Our Ref: BE/27/22/NMA

**Section 96A of the Town & Country Planning Act 1990 (as amended)
Town and Country Planning (Development Management Procedure) (England) Order 2015
(as amended) - Article 10**

Non material amendment following BE/121/21/RES for external alterations to approved building to reflect tenant requirements and addition of hip feature to roof.

Unit 3 land at Saltbox West of Shripney Road Bognor Regis PO22 9NW

Roof plan

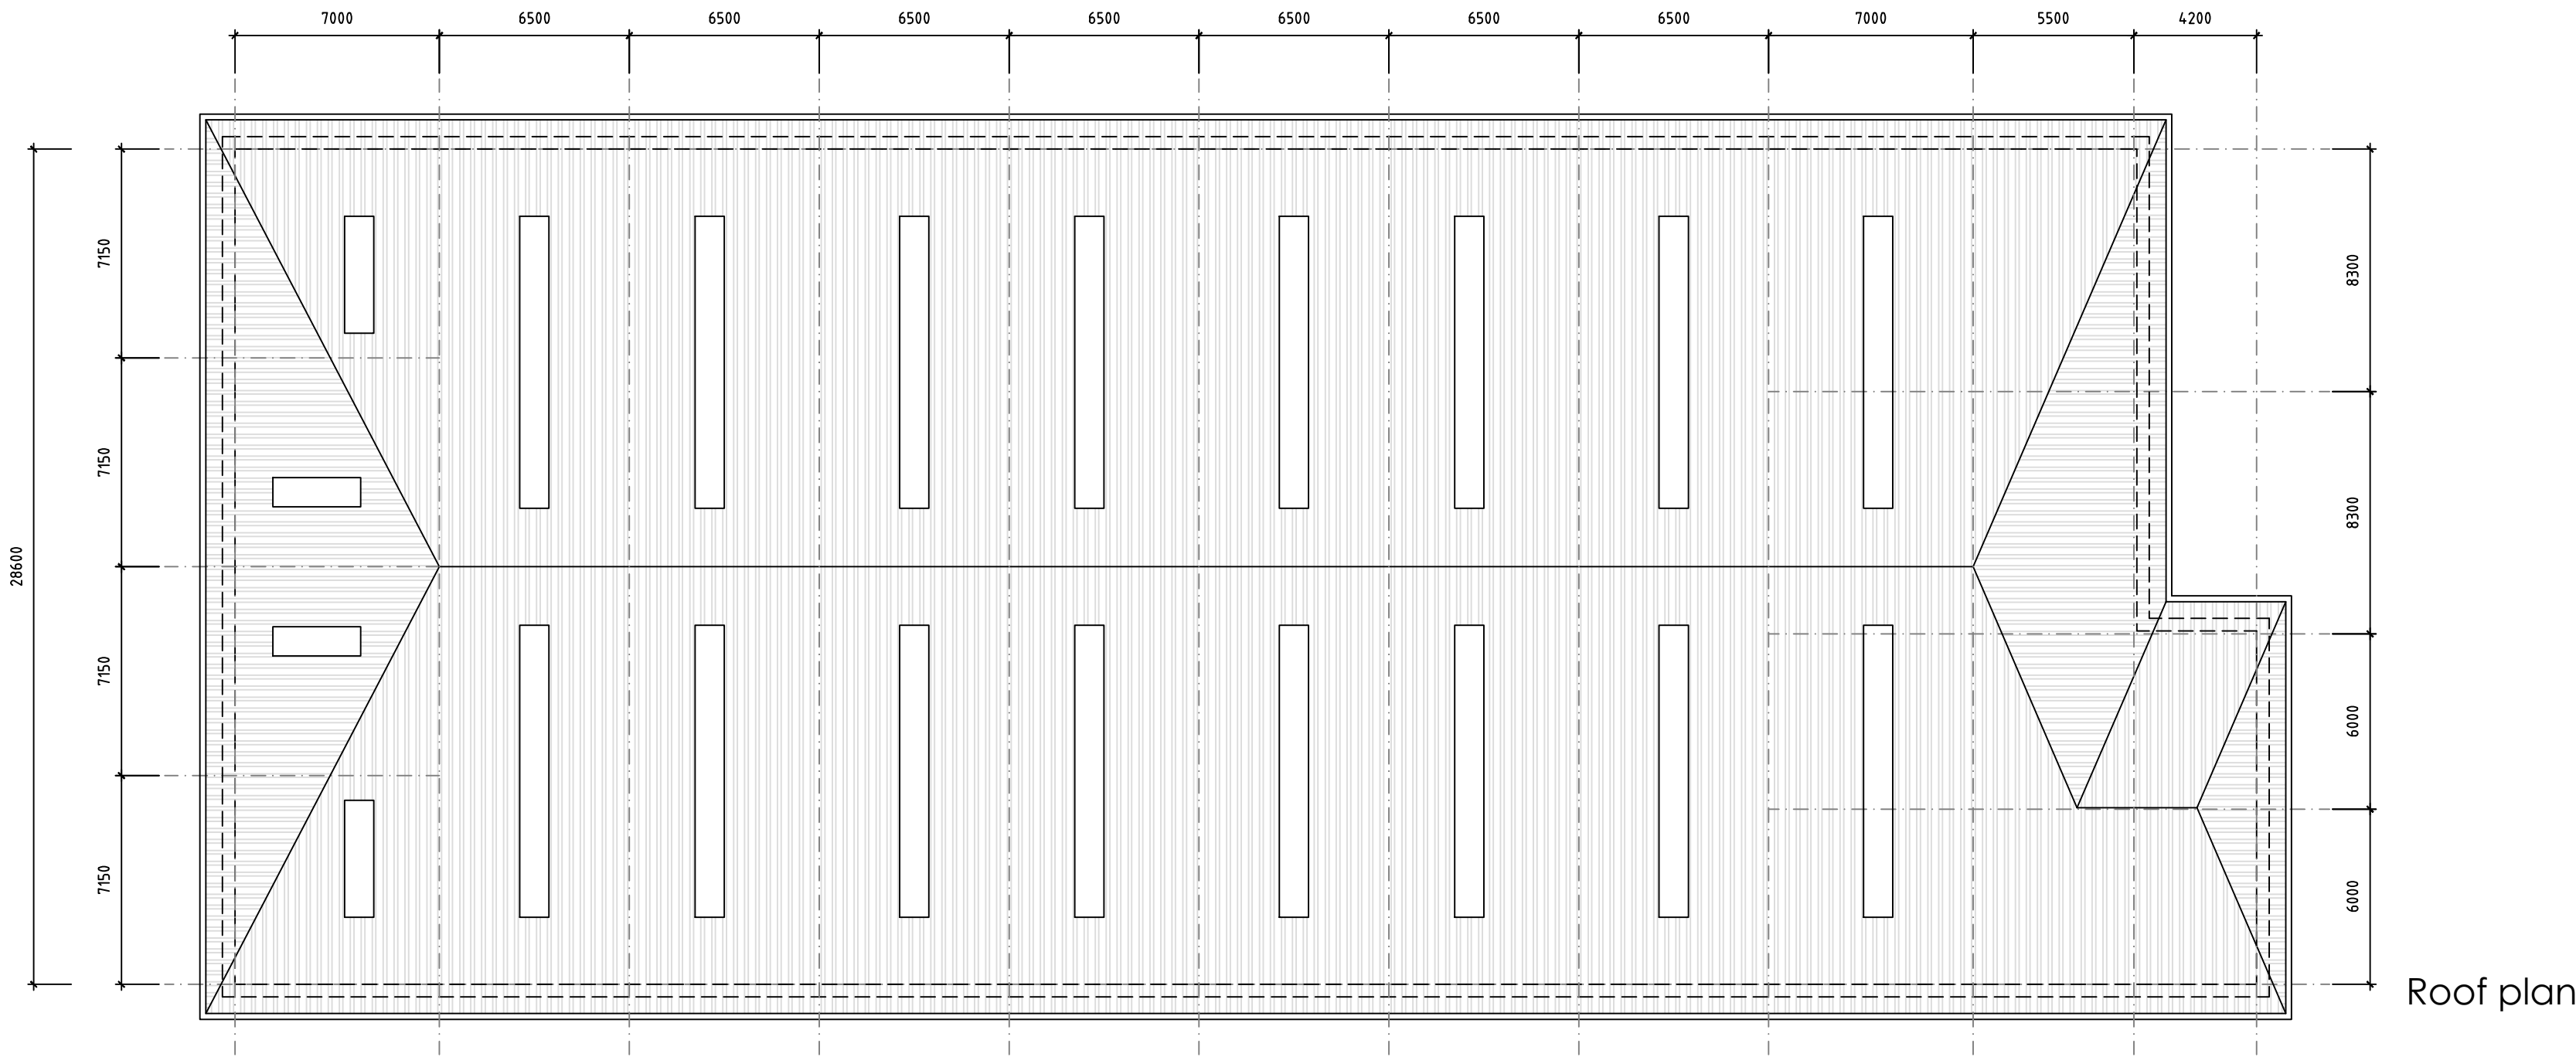
This Non-material amendment application seeks to alter the roof form to Unit 3 to have a hipped roof on application BE/121/21/RES at Saltbox, Bersted, in addition to this the applicant seeks to change the choice of materials.

The reason that this proposal has been accepted as a Non-Material Amendment is because it is proposing an alteration to the roof form of Unit 3 to see the addition of a hipped roof, and a change in materials. The proposal can therefore be considered under Section 96A of the Town and Country Planning Act 1990. The proposed alteration to the roof and materials would not change the description or conflict with any condition imposed on the Reserved Matters application. The addition of a hipped roof form would not result in changes to the external details that would materially alter the appearance of Unit 3. The external materials now include:

Please note that Drawing No. KP-281-Unit 3-NMA-01 Proposed Roof Plan and Elevations now form part of the approved planning drawings for BE/121/21/RES at Salt Box in place of:

Title
Unit 3
Proposed roof plan &
elevations

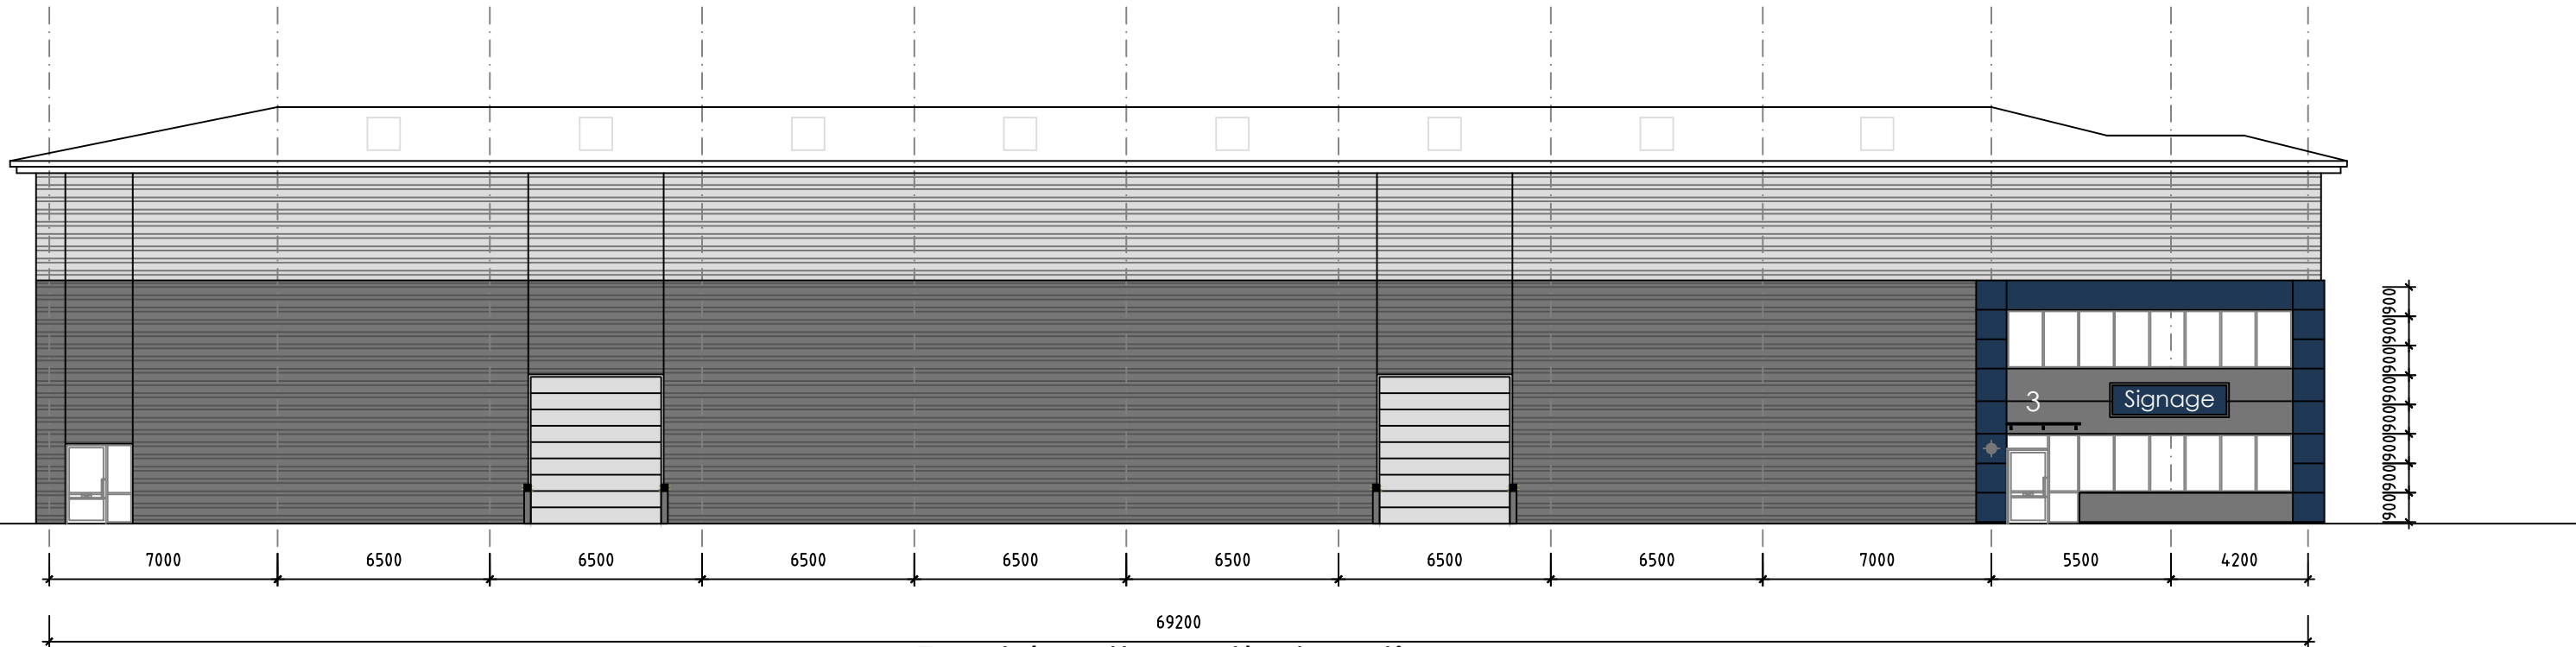
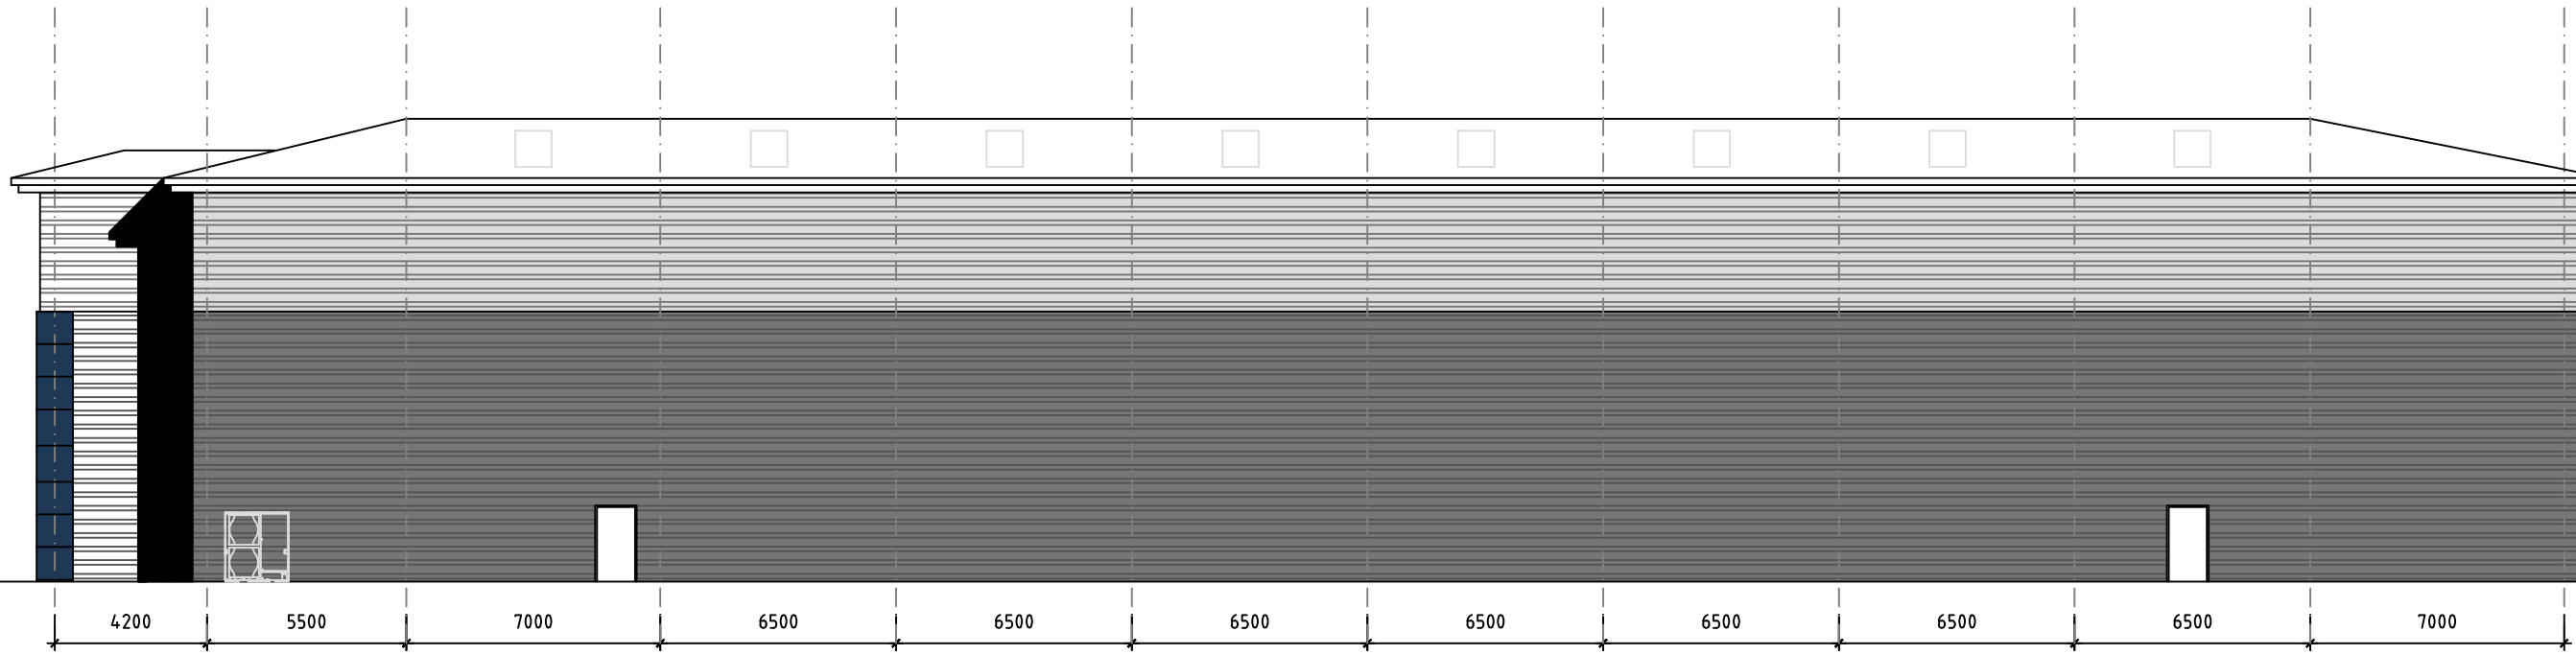
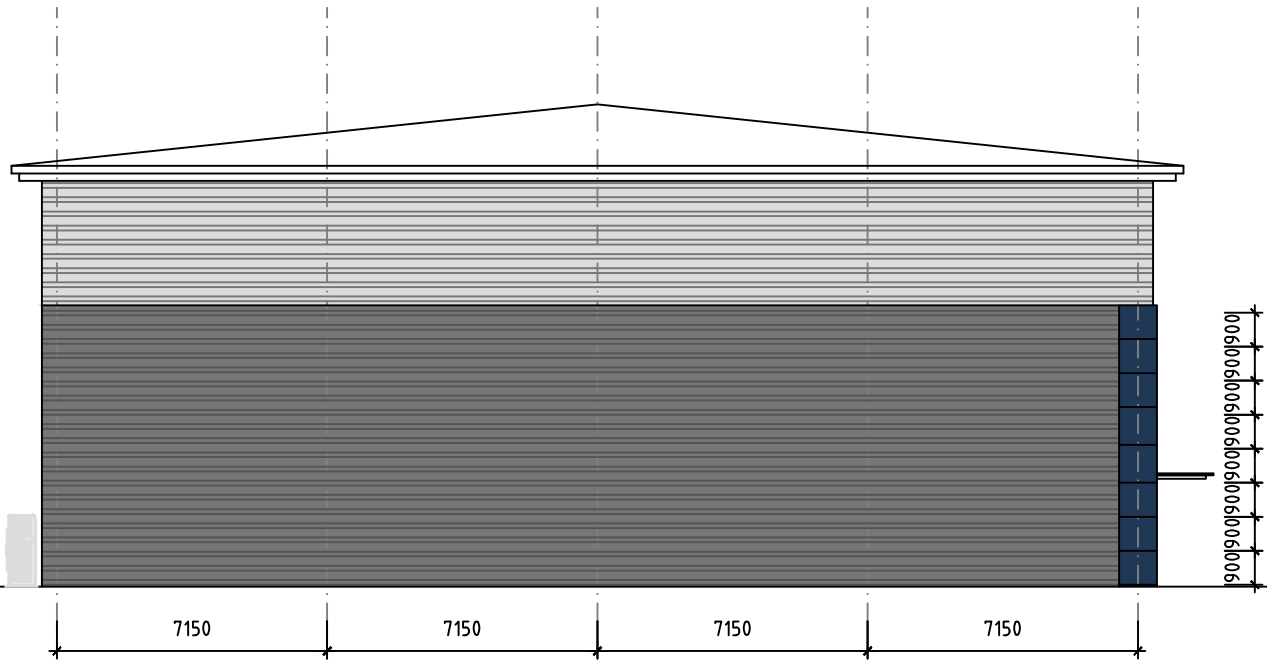
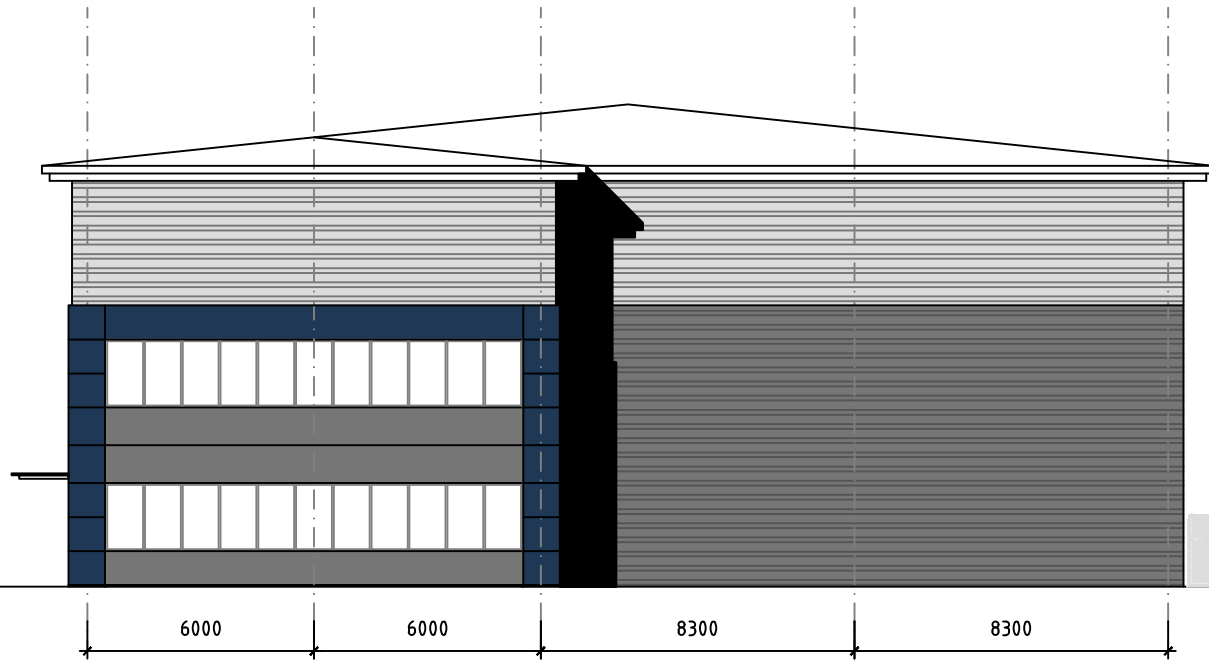
- Profiled built-up roof cladding in HPS200 Goosewing Grey BS A10A05
- Circular RWPs in Grey Aluminium RAL 9006 or Sargasso Blue RAL 5003 to match adjoining cladding.

- Gutter fascia in Grey Aluminium RAL 9007
- Horizontally laid profiled built-up wall cladding (half-round or trapezoidal) and related flashings in Metallic Silver colour RAL 9006
- Horizontally laid Microrib composite wall cladding in Sargasso Blue RAL 5003
- Horizontally laid Microrib composite wall cladding in Grey Aluminium RAL 9007
- Coloured insulate loading doors in Grey Aluminium RAL 9007
- Powder coated windows and curtain walling in RAL 9007
- Fire escape doors in RAL 9006 to match cladding
- Glazed spandrel panels
- Turn opening windows
- Unit name panatrim boards
